CITY OF ALBUQUERQUE

Planning Department
Alan Varela, Director

Re: NM Sol/ Phase 1 Tenant Addition
7402 Los Volcanes Rd. NW
Traffic Circulation Layout
Architect's Stamp 03-28-23 (J10-D027)

Based upon the information provided in your submittal received 04-11-23, the above referenced plan cannot be approved for Building Permit until the following comments are addressed:

ARCHITECTURAL SITE PLAN
Overall
Traffic Circulation Layout

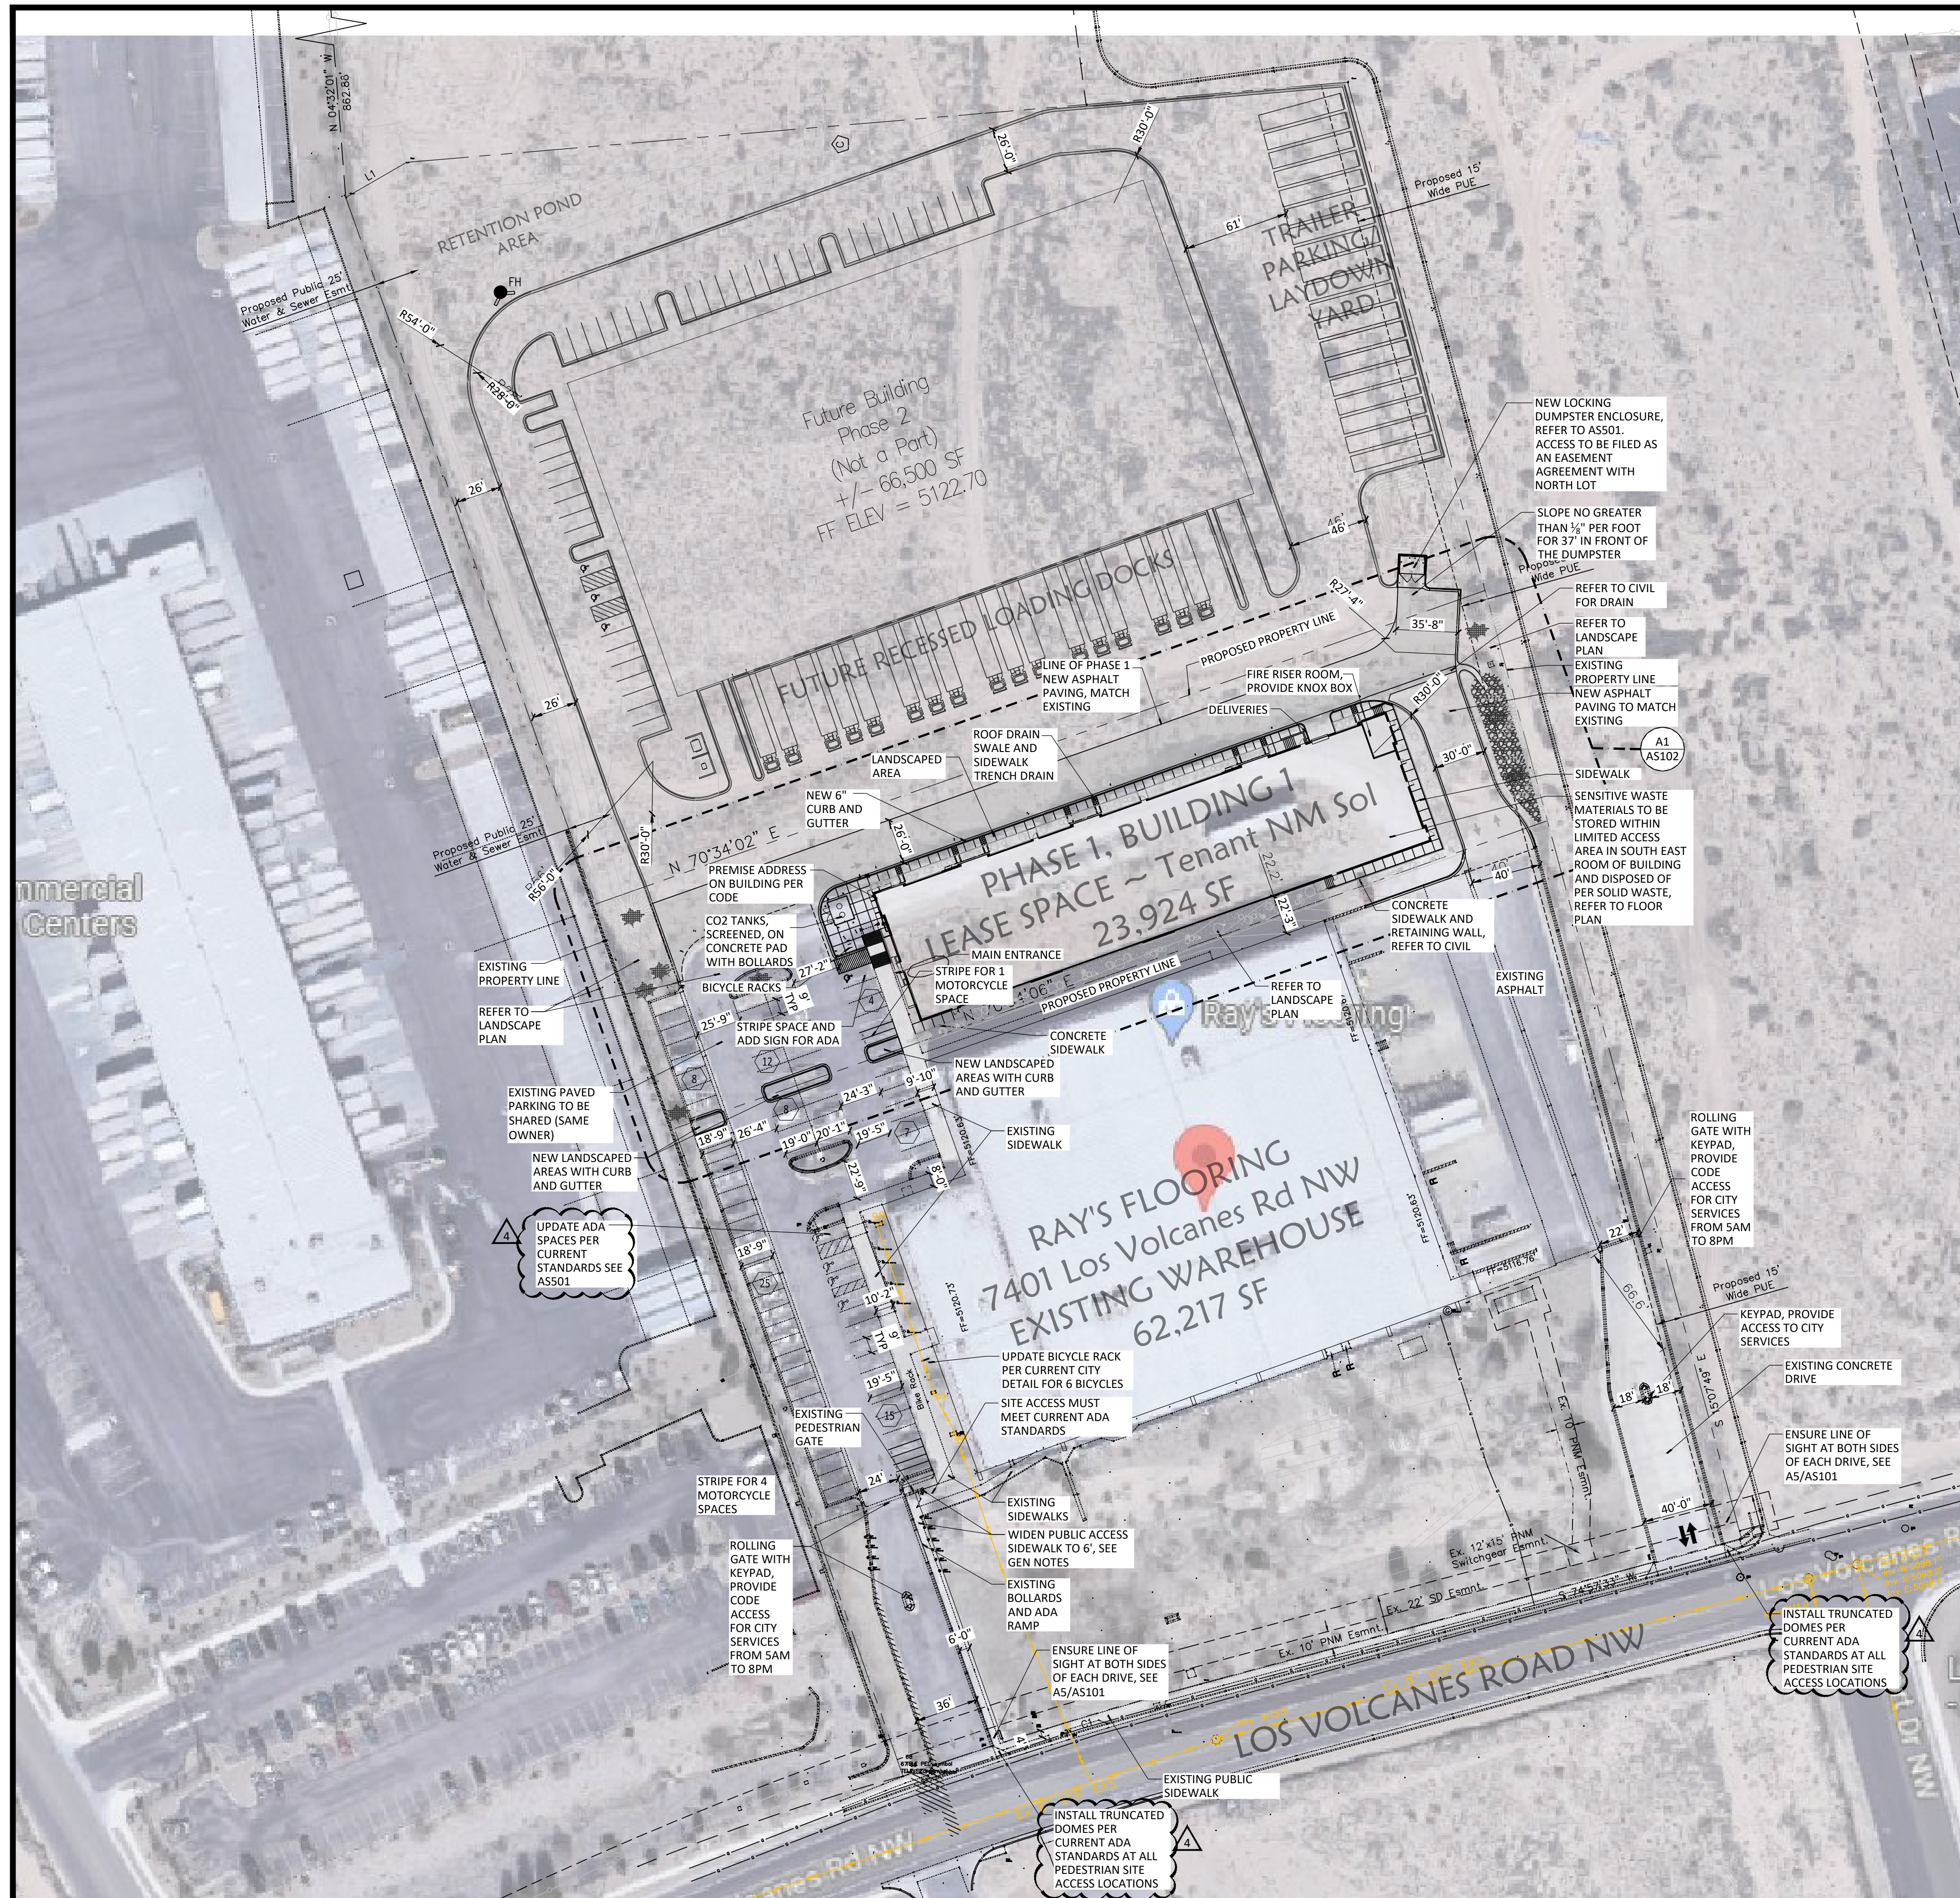
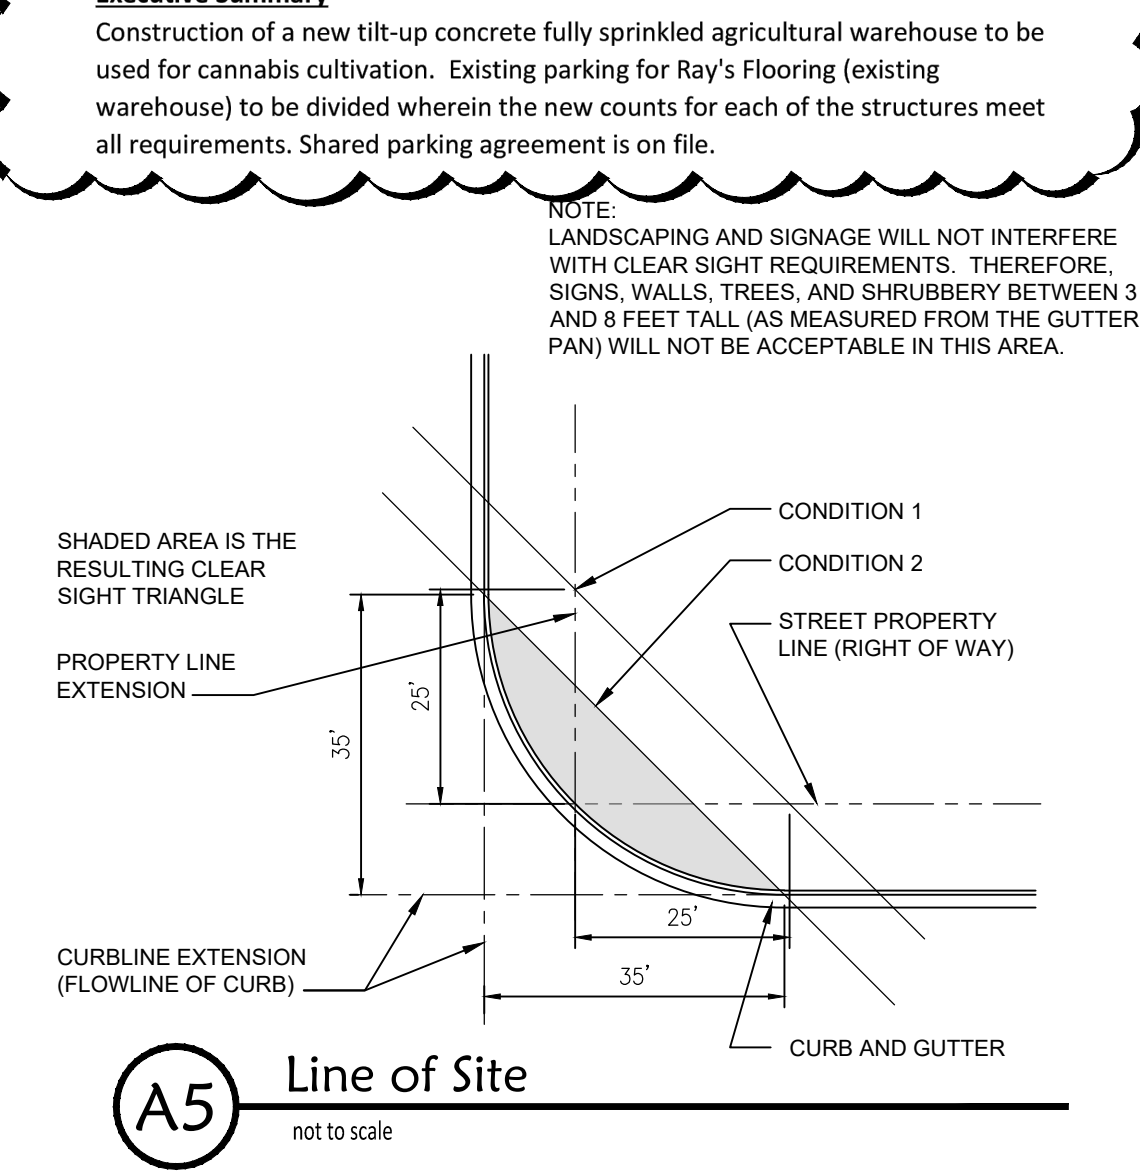
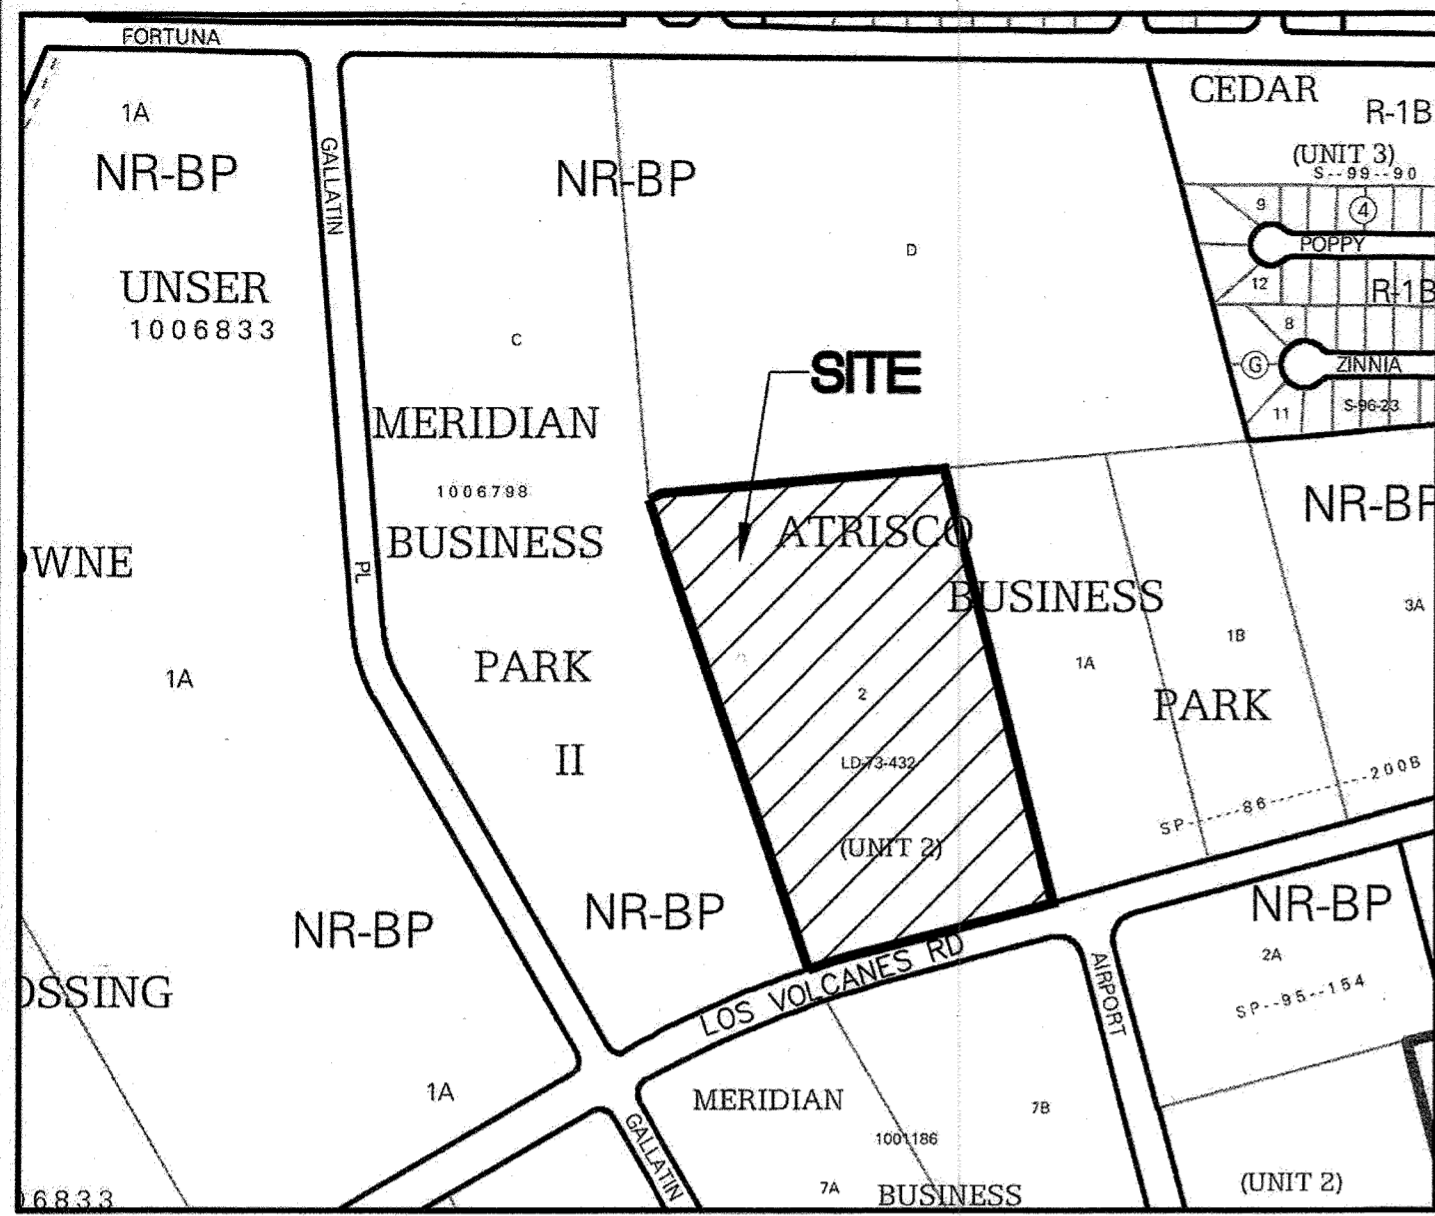
1. Identify all existing access easements and rights of way width dimensions.
2. Is the proposed Warehouse behind or in front of the existing building? Please clarify.
3. Please show the site accesses on the site plan, and site accesses must be updated to the current ADA standard.
4. Please show the dimensions for all the proposed parking spaces.
5. Show all drive aisle widths and radii. Some dimensions are not shown.

6. Per the IDO, a 6 ft. wide ADA accessible pedestrian pathway is required from the public sidewalk to the building entrances. Please clearly show this pathway and provide details.
7. Per DPM, a 6 ft. wide ADA accessible pedestrian pathway is required from the ADA parking stall access aisles to the building entrances. Please clearly show this pathway and provide details.
8. ADA accessible pedestrian pathway should not be placed behind parking space or adjacent to a vehicular way. Vehicle and pedestrian/wheel chair conflicts should be avoided as much as possible.
9. Curbing should be installed to delineate landscape, parking, and pedestrian ways and identify points of access. Please call out detail and location of barrier curb.
10. Refuse vehicle maneuvering shall be contained on-site. The refuse vehicle shall not back into the public right of way.; provide a copy of refuse approval.

11. Please provide a copy of Fire Marshal approval.
12. It is not apparent what type of pavement surface is being proposed. A hard driving surface will be required as part of this proposed project for parking area and drive aisles.

13. Show the clear sight triangle and add the following note to the plan: "Landscaping and signage will not interfere with clear sight requirements. Therefore, signs, walls, trees, and shrubbery between 3 and 8 feet tall (as measured from the gutter pan) will not be acceptable in the clear sight triangle.

14. Please specify the City Standard Drawing Number when applicable.
15. Add a note stating "All broken or cracked sidewalk must be replaced with sidewalk and curb & gutter." A build note must be provided referring to the appropriate City Standard drawing.
